Sterling Ranch Sketch Plan  
2023 Amendment & Rezone  
Traffic Technical Memorandum  
PCD Filing Nos. SKP235, P239, P2310, and P2311  
(LSC #S224441)  
December 15, 2023

LSC Responses to TIS  
Redline Comments

# LSC Responses to Sterling Ranch SKP\_TIS Redlines - Jan 2024

Figure 5
Proposed Roadway Functional Classification

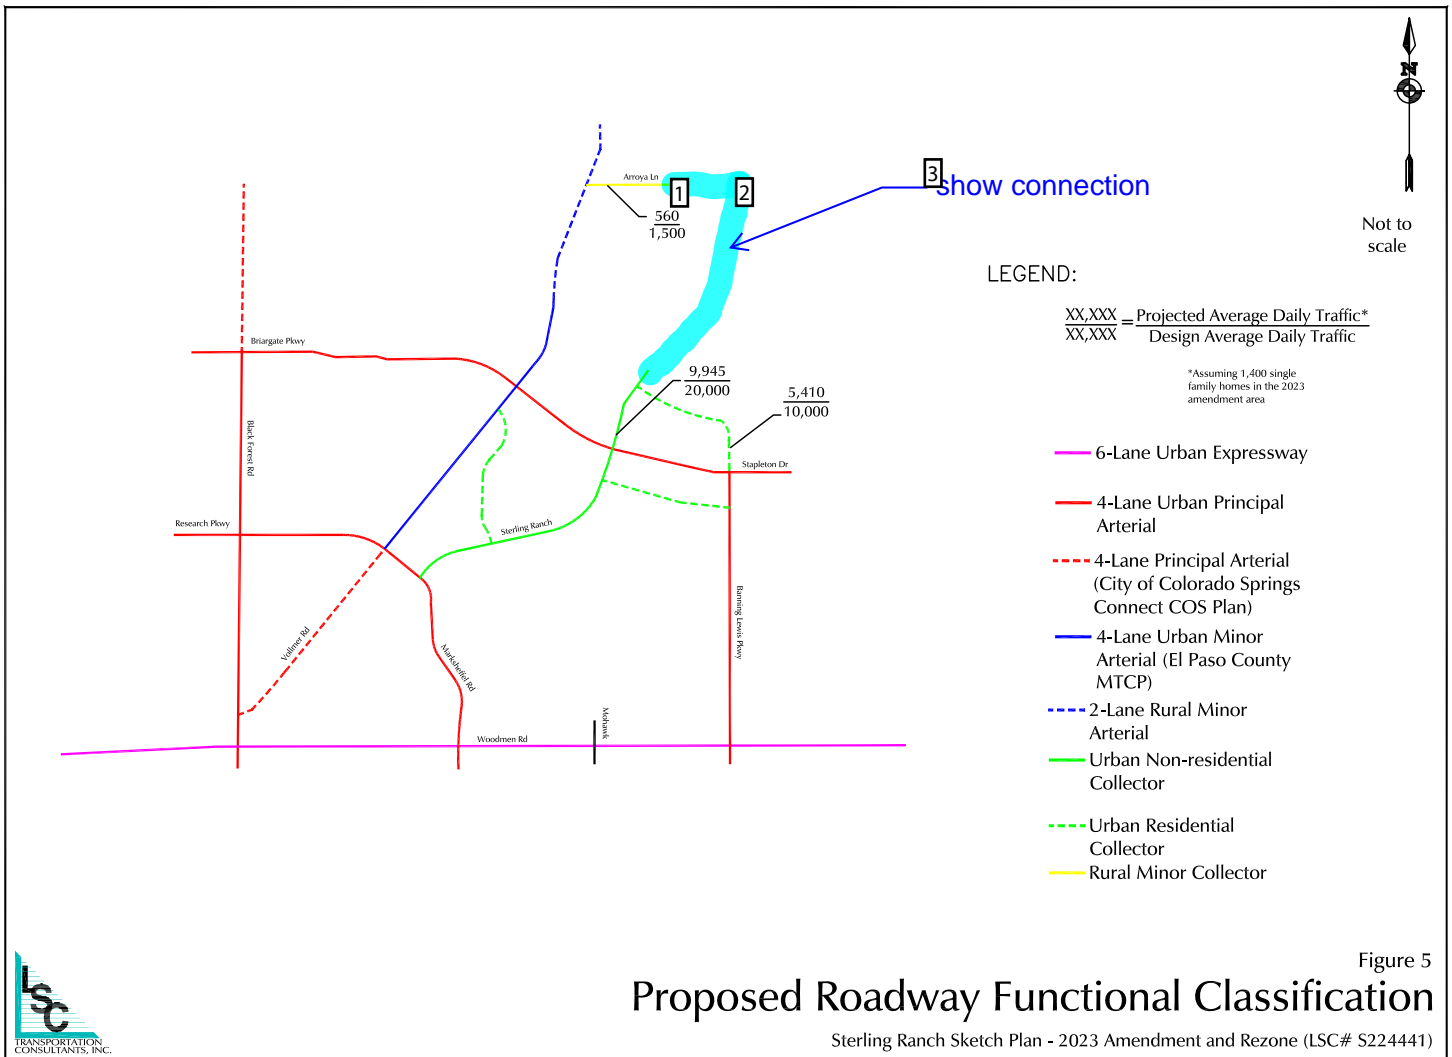
[Add street names](#)

Author: kdferrin    Subject: Sticky Note    Date: 1/17/2024 11:52:32  
LSC Response: The figure has been revised as requested.
